**EL PASO COUNTY PLANNING AND  
 COMMUNITY DEVELOPMENT  
 DEPARTMENT**

**GRADING AND EROSION CONTROL PLAN CHECKLIST**

Revised: July 2019

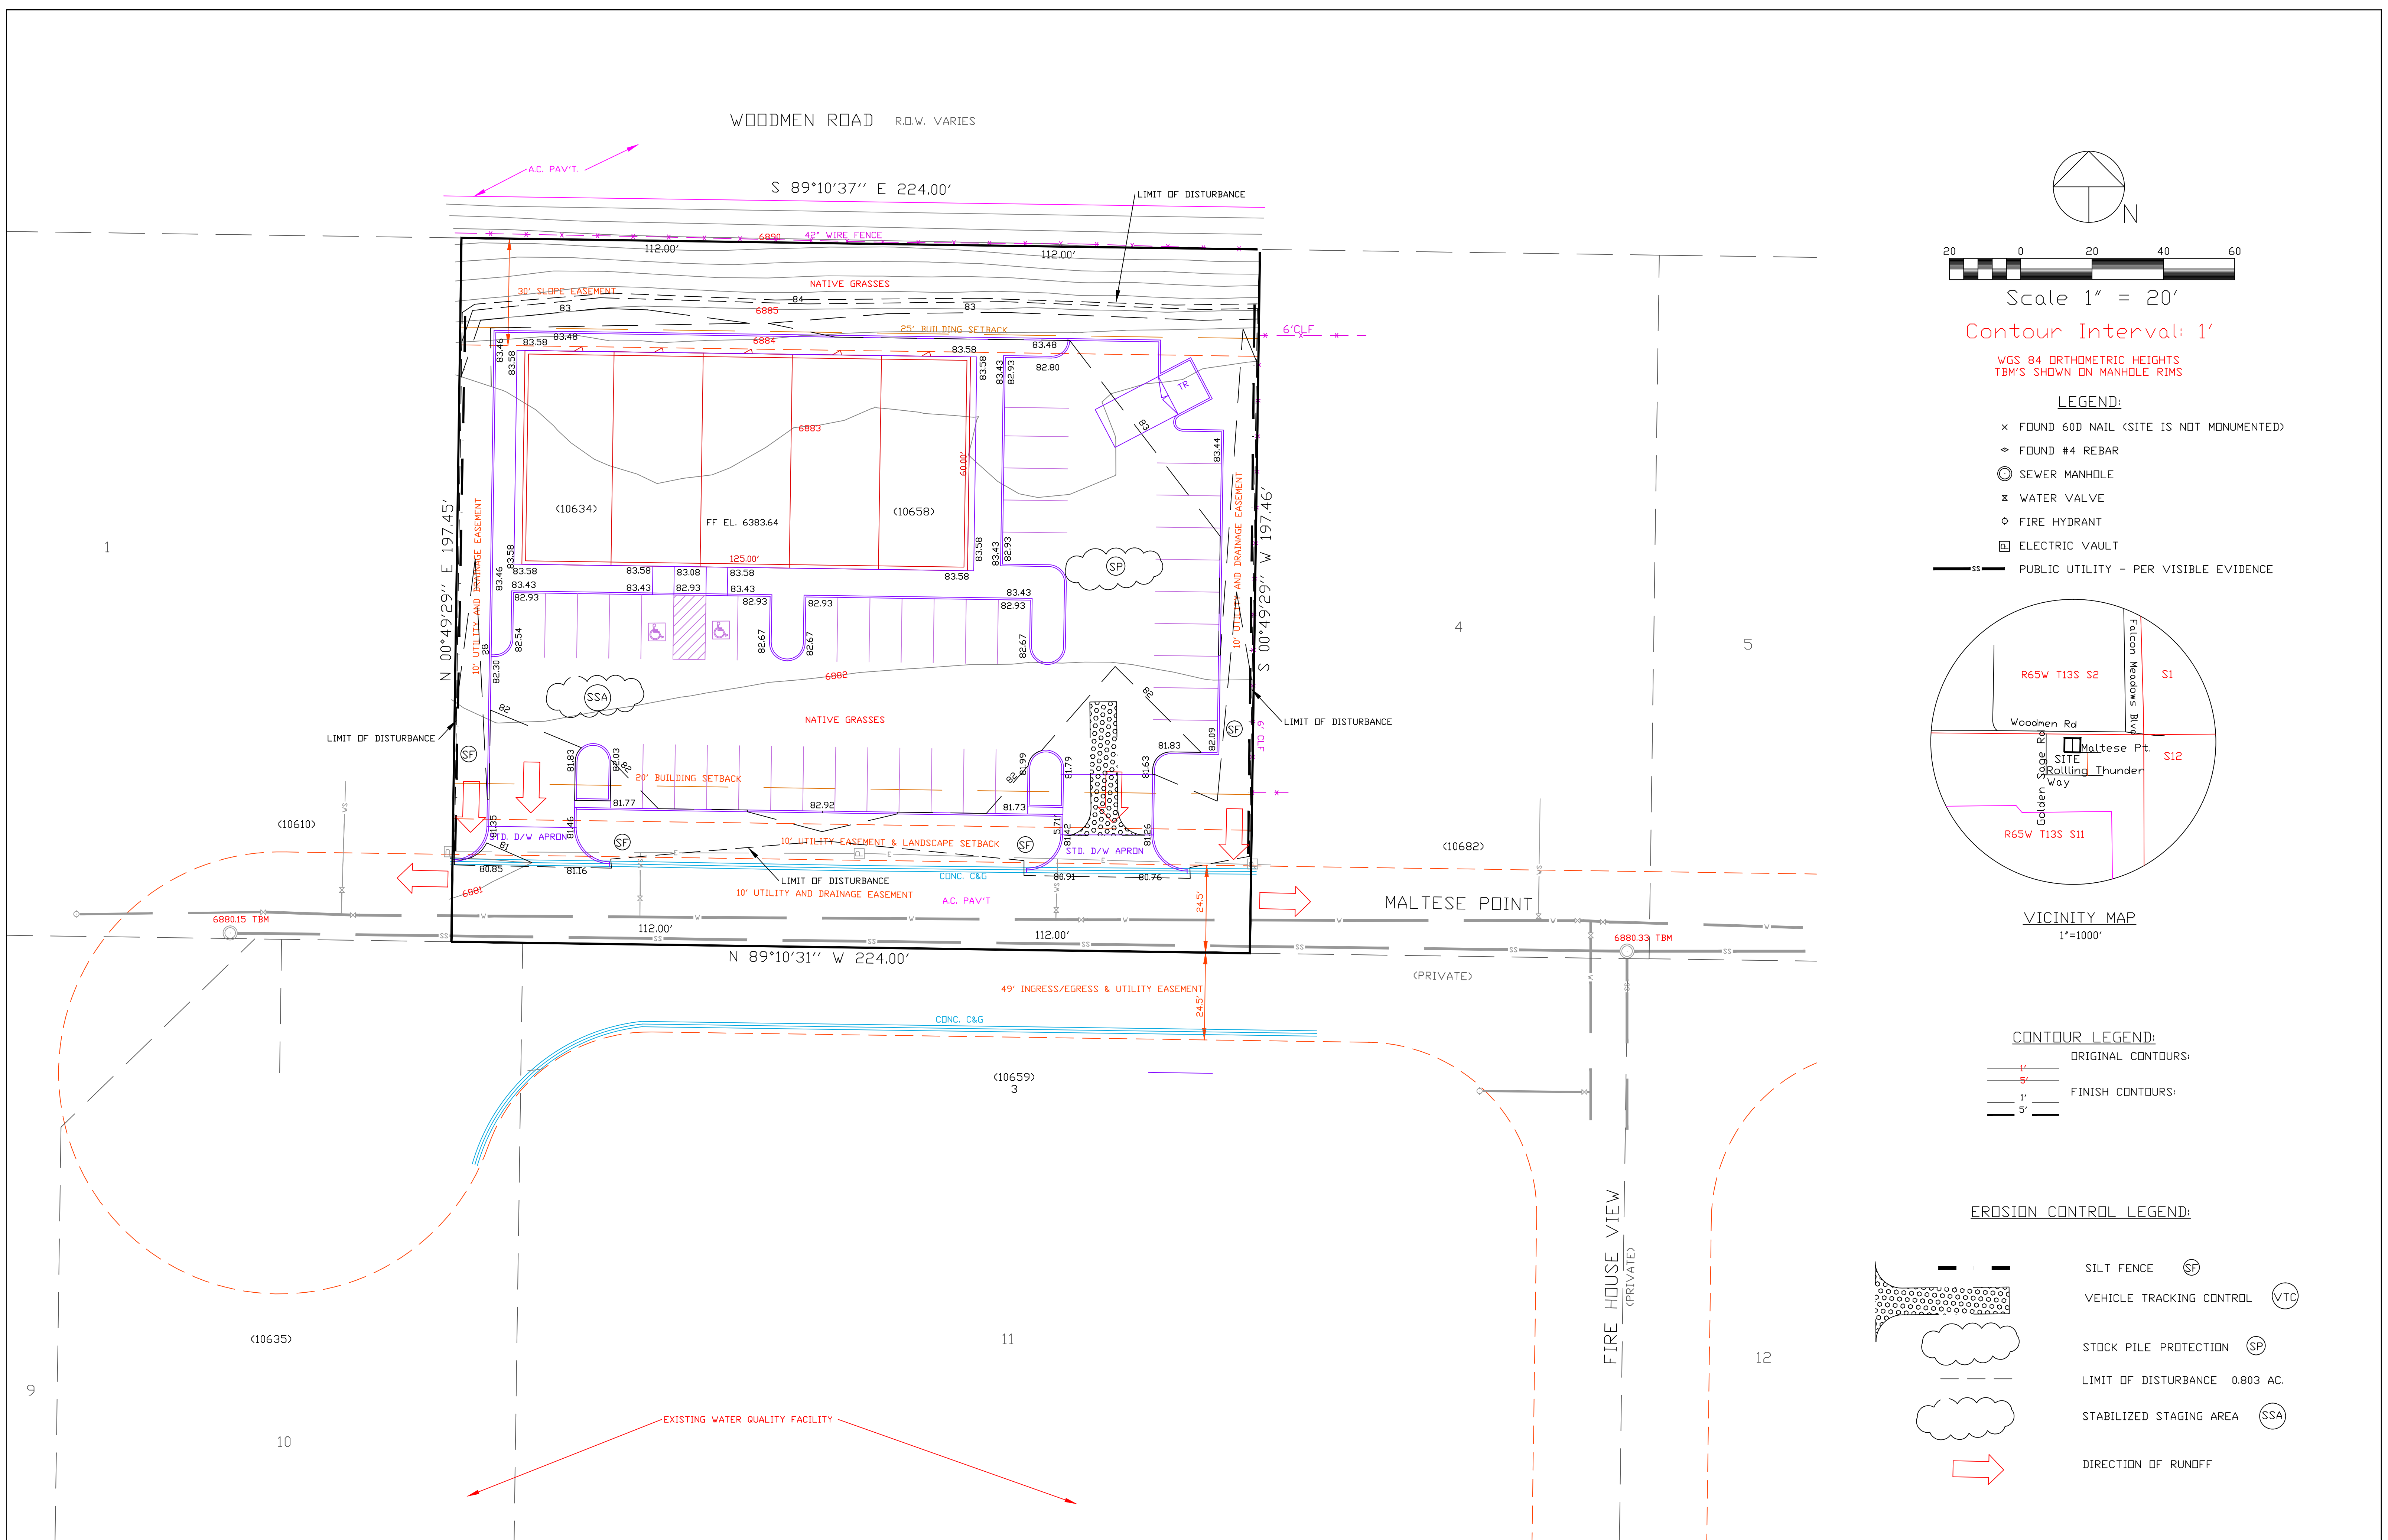
v	All proposed temporary construction control measures, structural and non-structural. Temporary construction control measures shall be identified by phase of implementation to include "initial," "interim," and "final" or shown on separate phased maps identifying each phase.	x	X
w	Vehicle tracking provided at all construction entrances/exits. Construction fencing, barricades, and/or signage provided at access points not to be used for construction.	x	X
x	Temporary sediment ponds provided for disturbed drainage areas greater than 1 acre.	n/a	N/A
y	Dewatering operations to include locations of diversion, pump and discharge(s) as anticipated at time of design.	x	N/A
z	All proposed temporary construction control measure details. Custom or other jurisdiction's details used must meet or exceed EPC standards.	n/a	X
